Ref 2450.corr.RVBC250807

Barn at Lower Reaps Farm, Whinney Lane, Mellor, BB2 7EL

Application references 3/2025/0507 and 0508

drawing number
pl.13

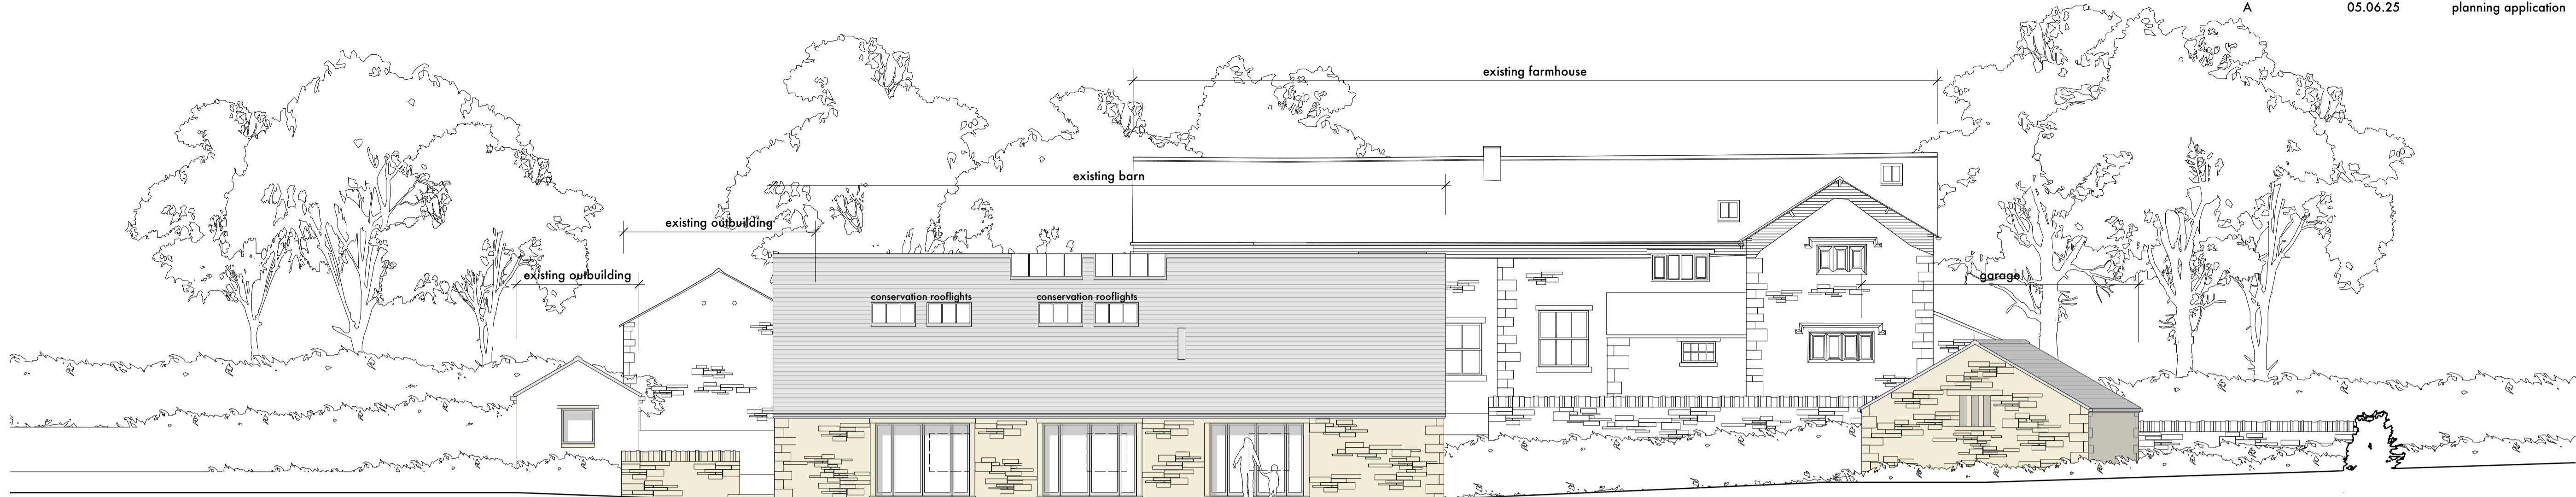
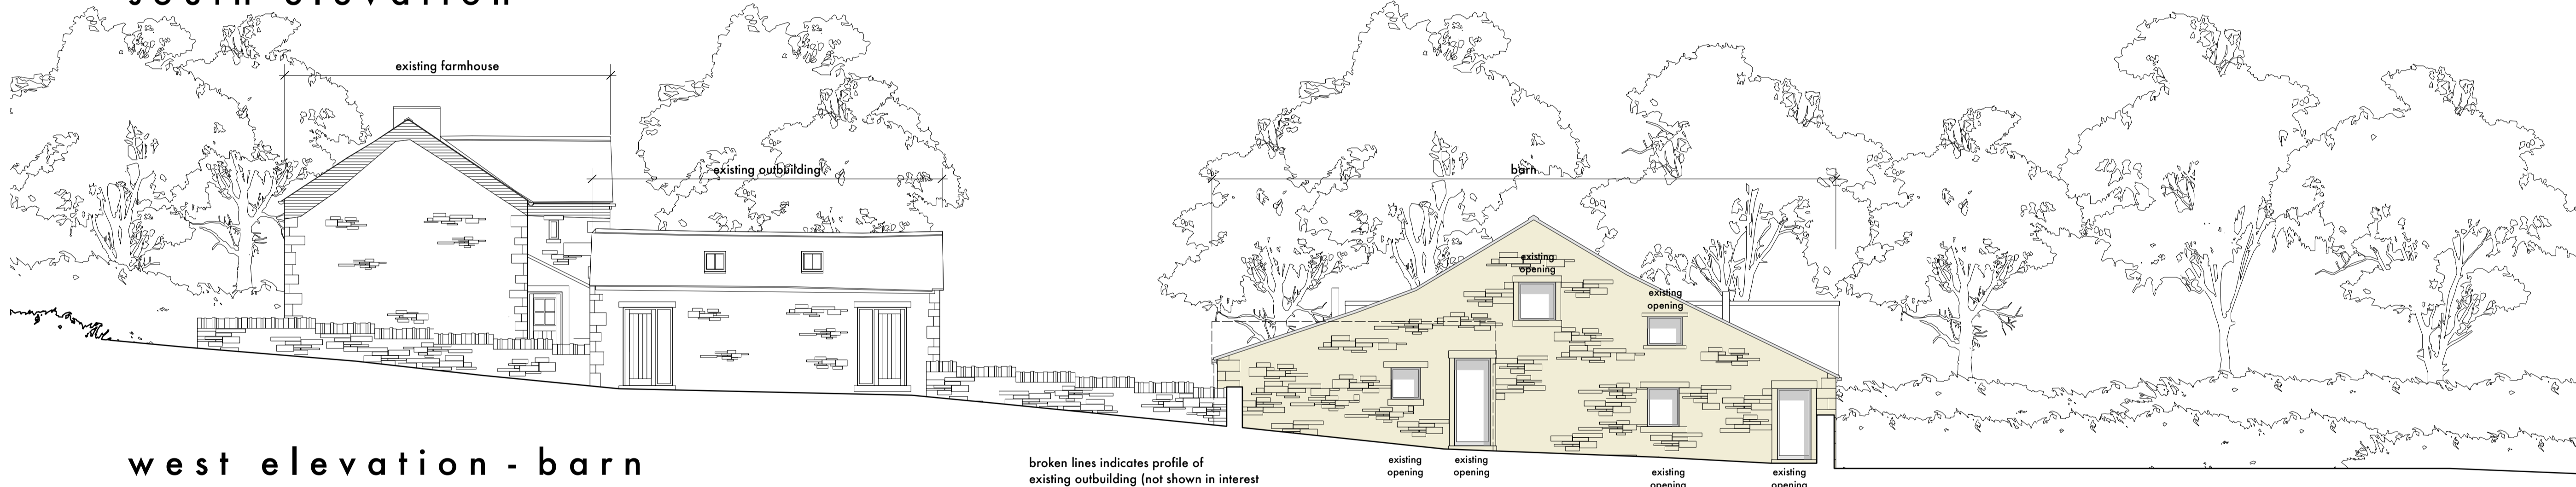
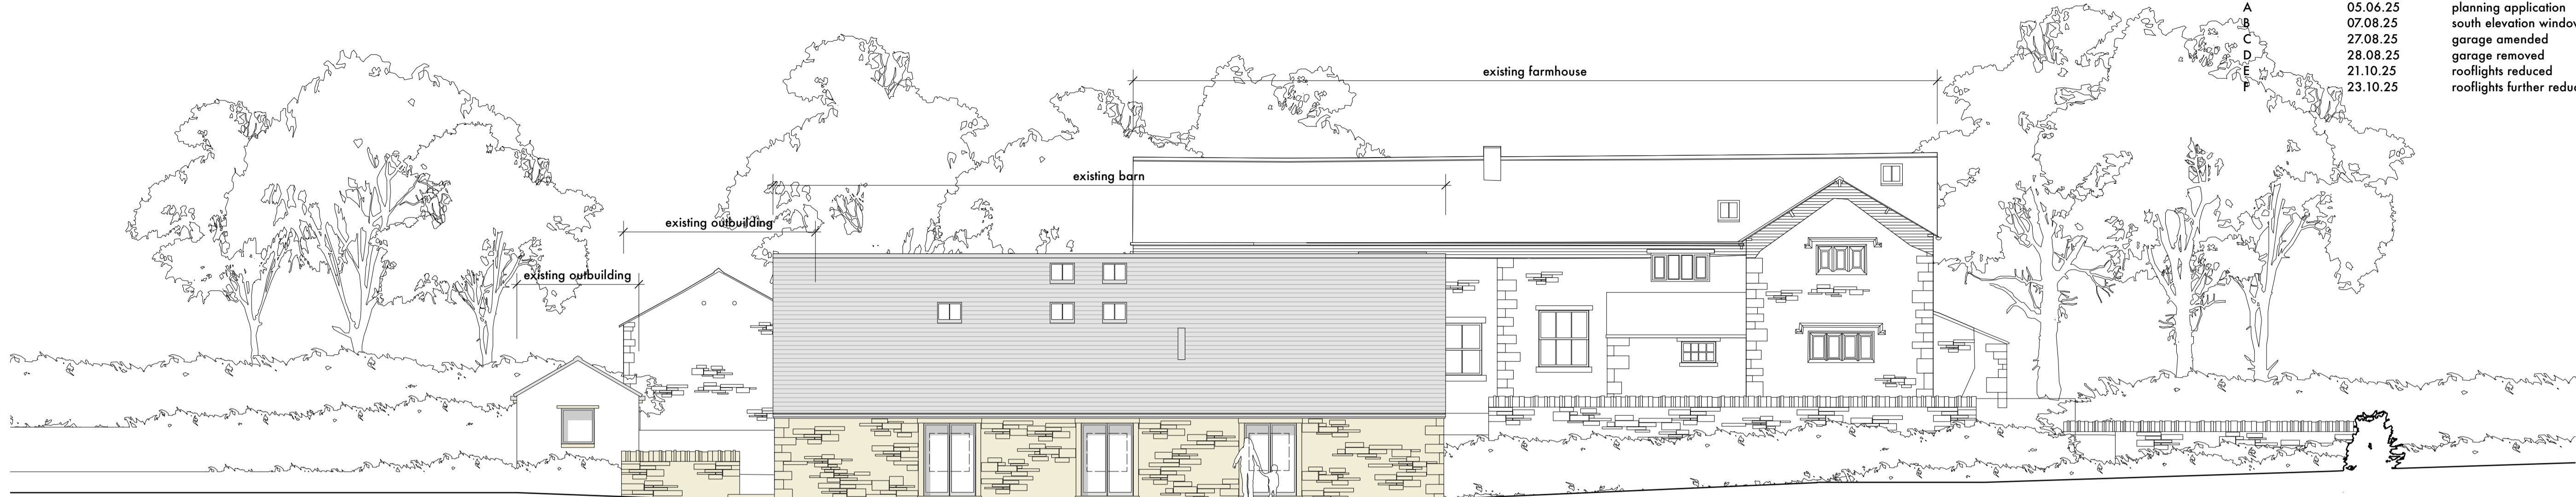
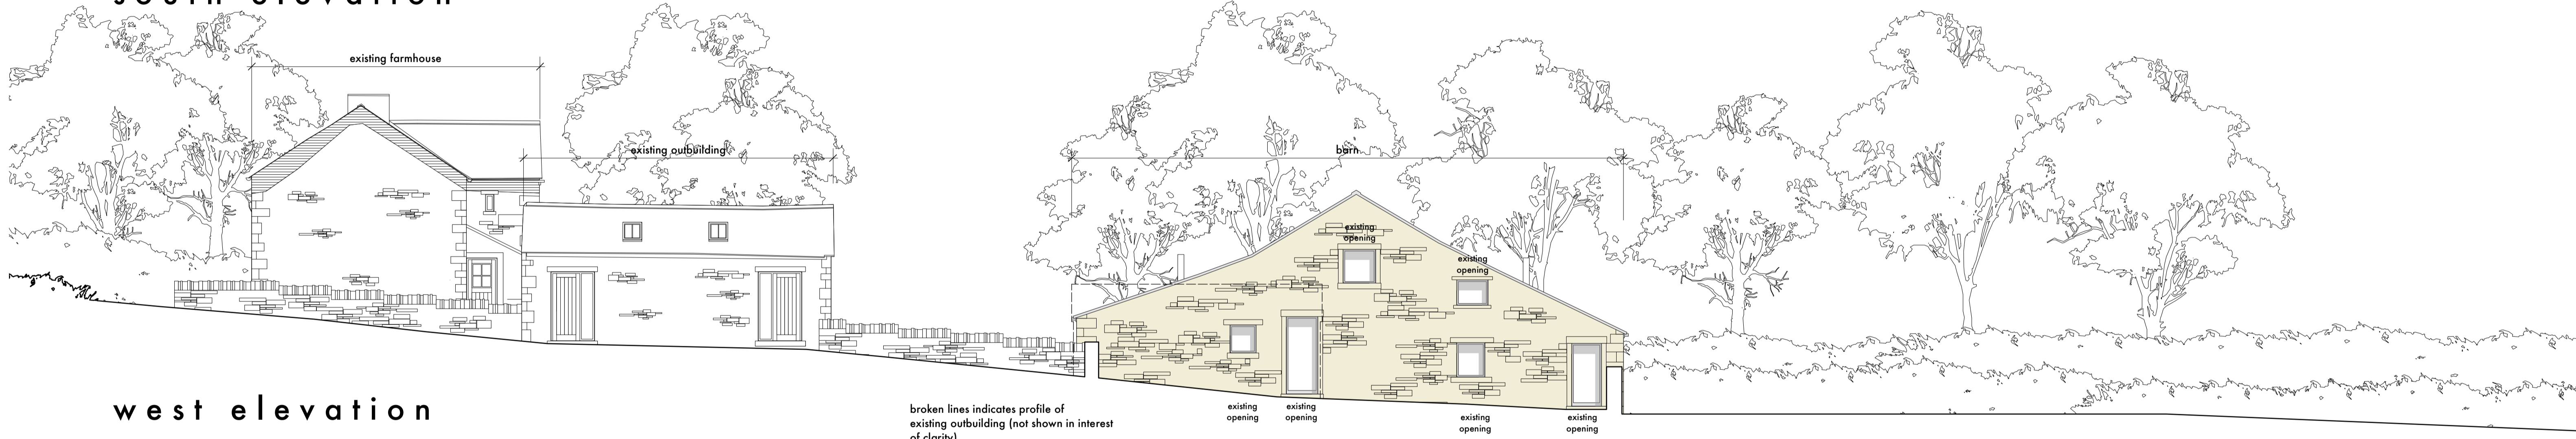
The CBA comment on proposed south facing openings and state the opinion that they 'erode the agricultural character of the building'. Following discussion with our client, the decision has been taken to further reduce the width of the proposed openings to now match the width of the existing openings to the neighbouring outbuilding. Dressed stone surrounds to the openings will be detailed to match the existing surrounds to door openings to the barn. The proposed openings will be fitted with 'French' style doors and not 'bifold' doors as suggested in the CBA correspondence. The proposed doors will be in keeping with the barn and setting whilst allowing access from the family room and principal bedroom to the garden. The reduced width will also help address the 'glare' suggested in the CBA correspondence.

Drg.no.2450/13 revision B

proposed - south and west elevations
